From: Paul Cann
Sent: 02 August 2017 17:20
To: Planning.Responses
Subject: RE: Planning Consultation on: BN/28/17/RES

Paul Cann
Senior Engineer (Drainage & Coastal)

APPLICATION BN/28/17/RES

Description of Works: Approval of reserved matters following outline consent
BN/32/15/OUT relating to appearance, landscaping, layout &
scale for erection of 38 No. dwellings including open space,
landscaping & new access

JOB NO.	DRAWING NO.	REV
MATT151202	SL.01	P5

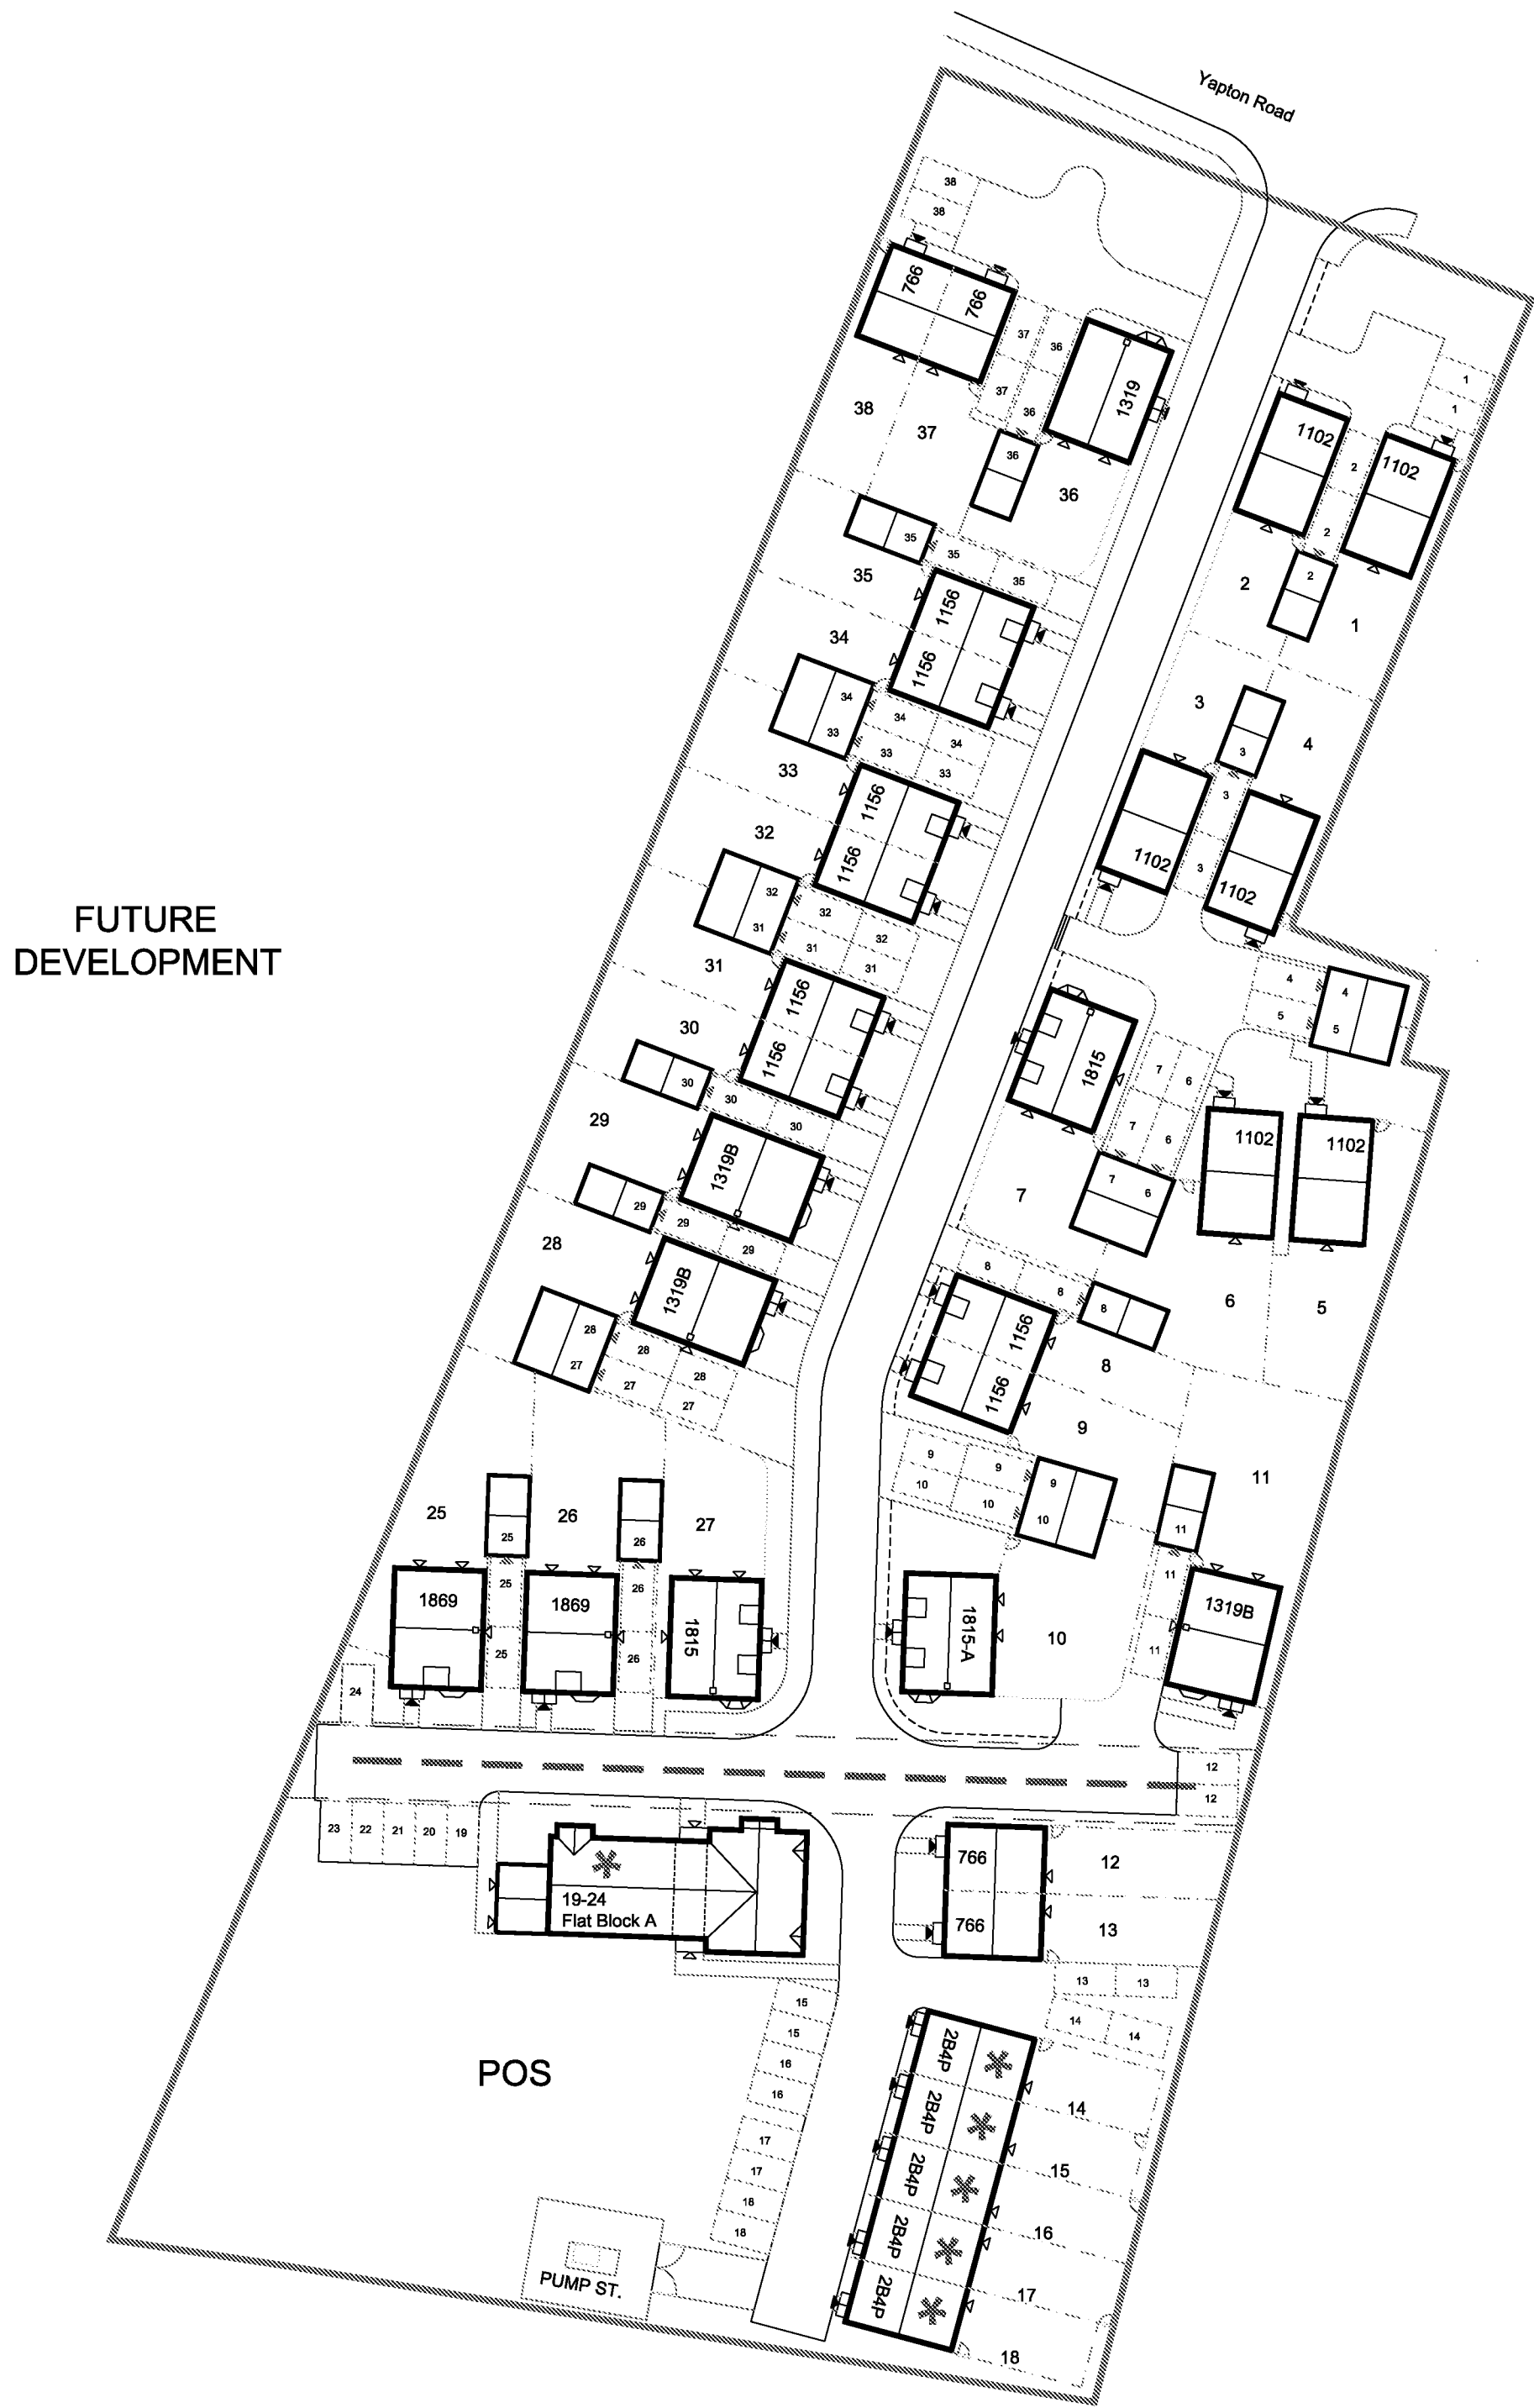
The proposed development layout does not satisfy condition no.9 in respect to maintaining access to the existing watercourse. A three metre wide easement strip is required from the top of the bank and to be free of all obstructions including boundary fences. The foul water pumping station compound and one of the dwellings conflicts with this requirement.

APPENDIX D

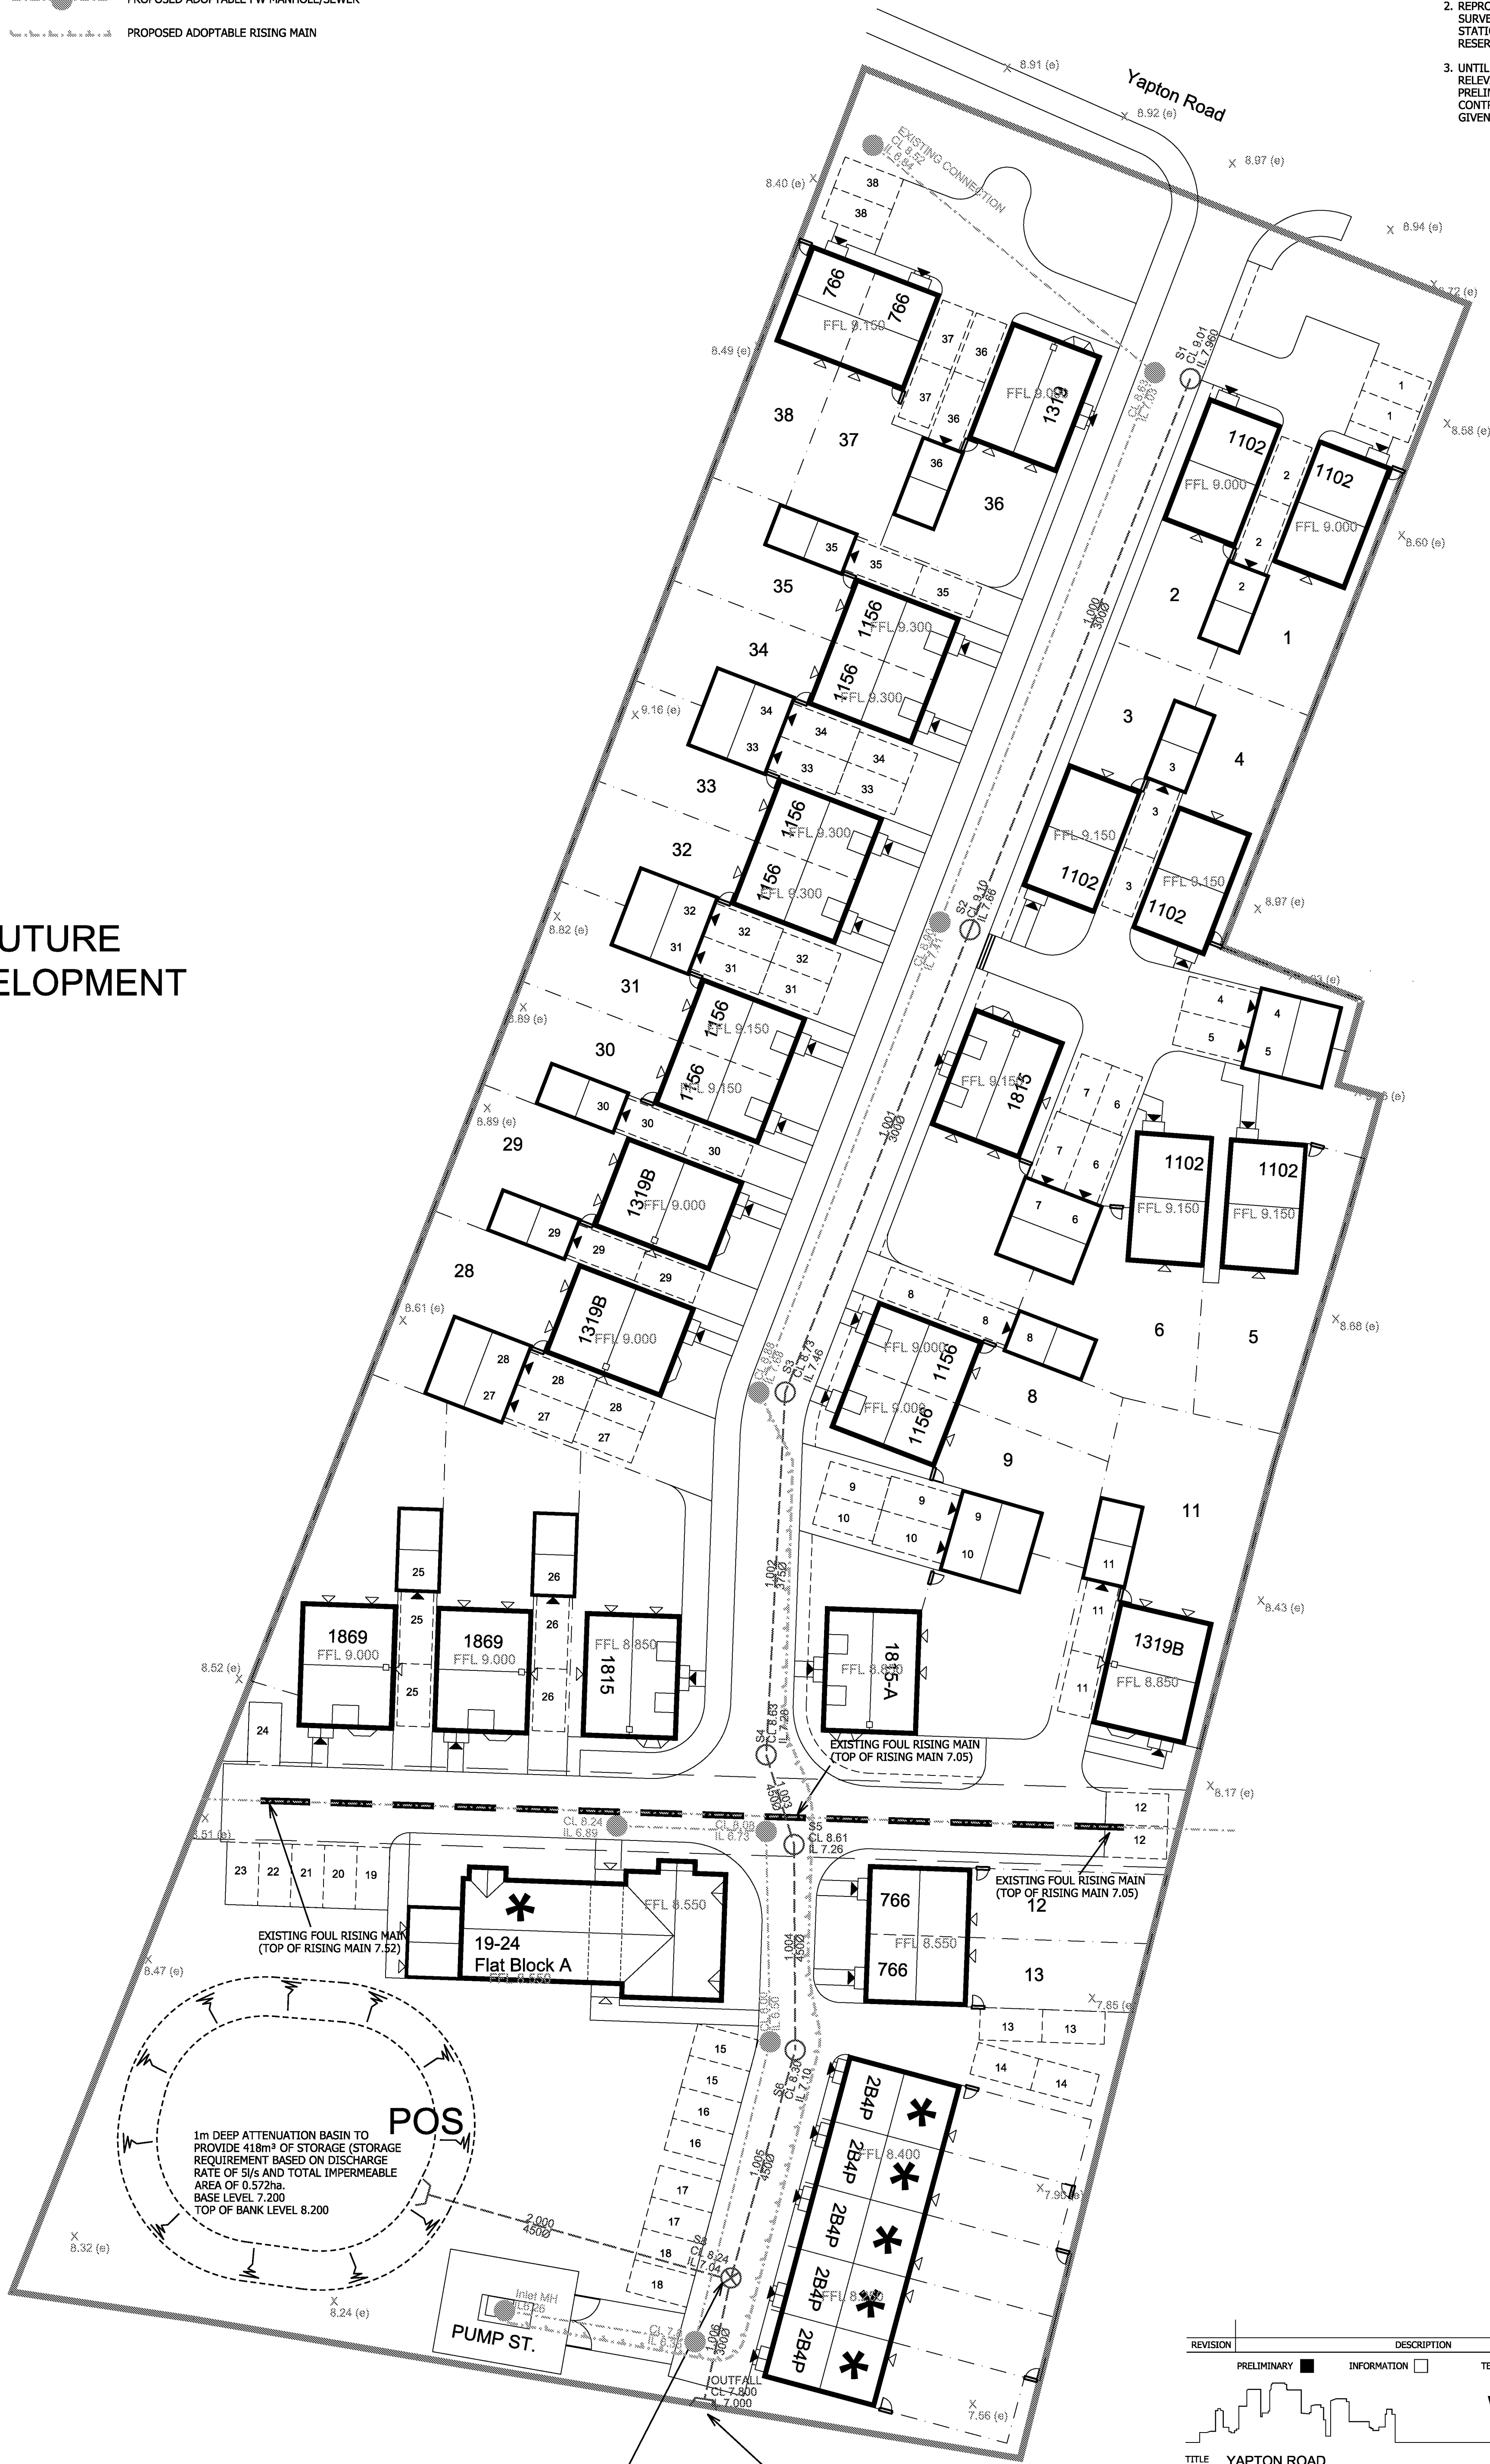
The principle of the surface water drainage scheme is acceptable, however, its detailed design will need to be agreed. This will include hydraulic calculations to confirm the sizing of the pond, construction details of the pond (taking into account potentially high groundwater levels/floatation), full details of the remainder of the surface water drainage system, improvements to the existing watercourse, etc. The applicant should also investigate the use of permeable paving where possible (with impermeable liners to combat the high water table) in order to provide a degree of water treatment/flow attenuation.
